**KIRKLEES METROPOLITAN COUNCIL  
INVESTMENT & REGENERATION SERVICE**

**DELEGATED DECISION TO DETERMINE PLANNING APPLICATIONS**

Reference No:	<b>2024/62/91549/E</b>
Site Address:	30, Heaton Avenue, Earlsheaton, Dewsbury, WF12 8AQ
Description:	Erection of front porch
Recommending Officer:	Faiza Bano

## HOUSEHOLDER DELEGATED REPORT

PROPOSED FRONT ELEVATION

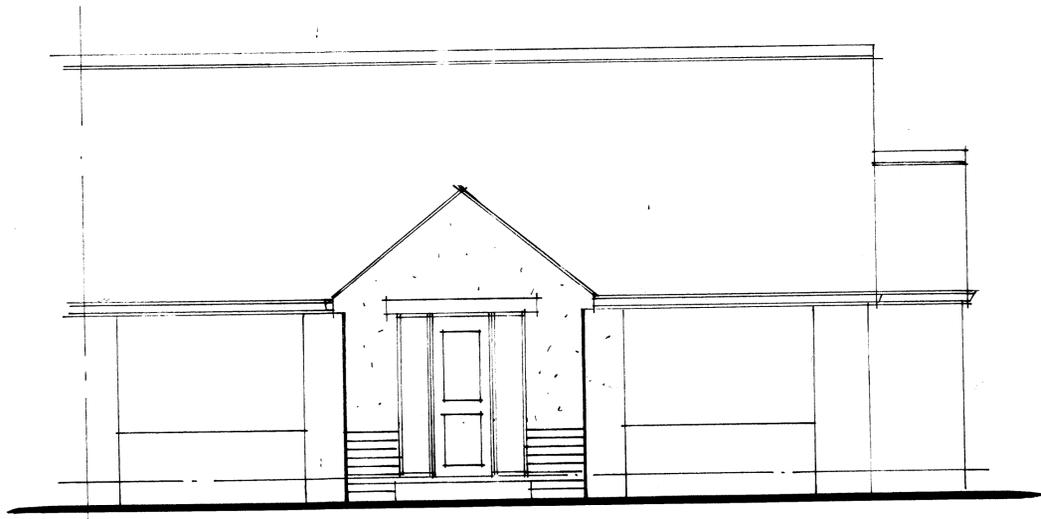
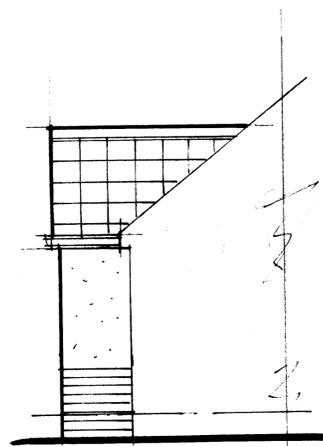
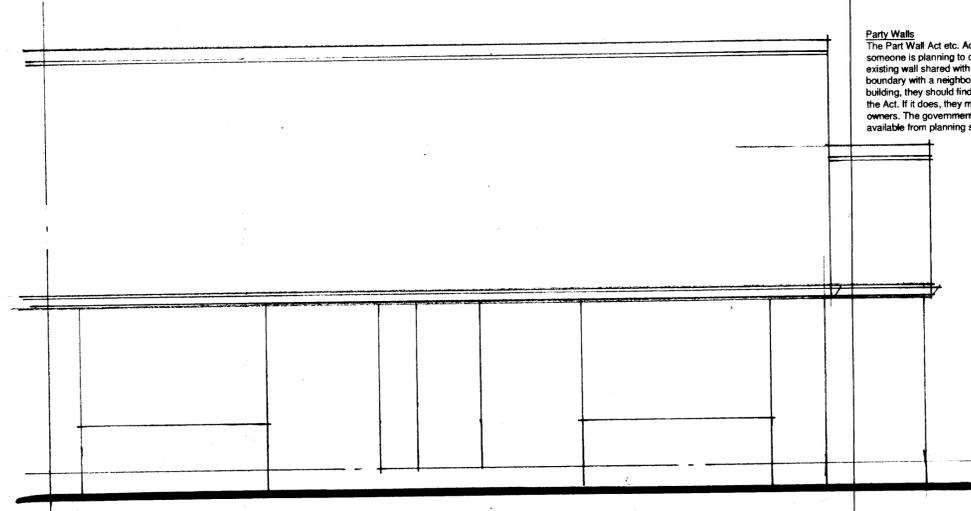
The porch would project 1000mm width a width of 3000mm and the roof form would be pitched, tying into the roof of the host property with the ridge set down from that of the host property.

The walls of the porch would be constructed using brick and render, with concrete tiles for the roof covering.

or is well screened; (5.14)		
The extension is small, subservient to the original building,	Yes	
well-designed and would not harm the character of the original house or the area;	Yes	
The materials and design match the existing features of the original house; a		No – original roof finishing is made up of rosemary tiles, which match adjoining property. However, the roof finishing for the entire property, including the proposed extension is to be replaced with concrete tiles – this is not considered to present an issue in terms of visual amenity due to the property being located within a mixed character and mixed house area. However, it must be noted that the walls, windows and doors are to match the existing materials of the dwelling.
The extension would not unreasonably affect the neighbouring properties	Yes

Whilst the development has seen the tiles of the host property changed it is likely this could be undertaken in any event to the roof of the host property by utilising pd rights. As such it is considered that in this case, subject to condition requiring the materials of construction to match those of the existing building, such a condition would be sufficient to ensure the satisfactory appearance of the development in terms of the materials of construction.

2. The external walls and roofing materials of the development hereby approved shall in all respects match those used in the construction of the existing building and be retained thereafter.
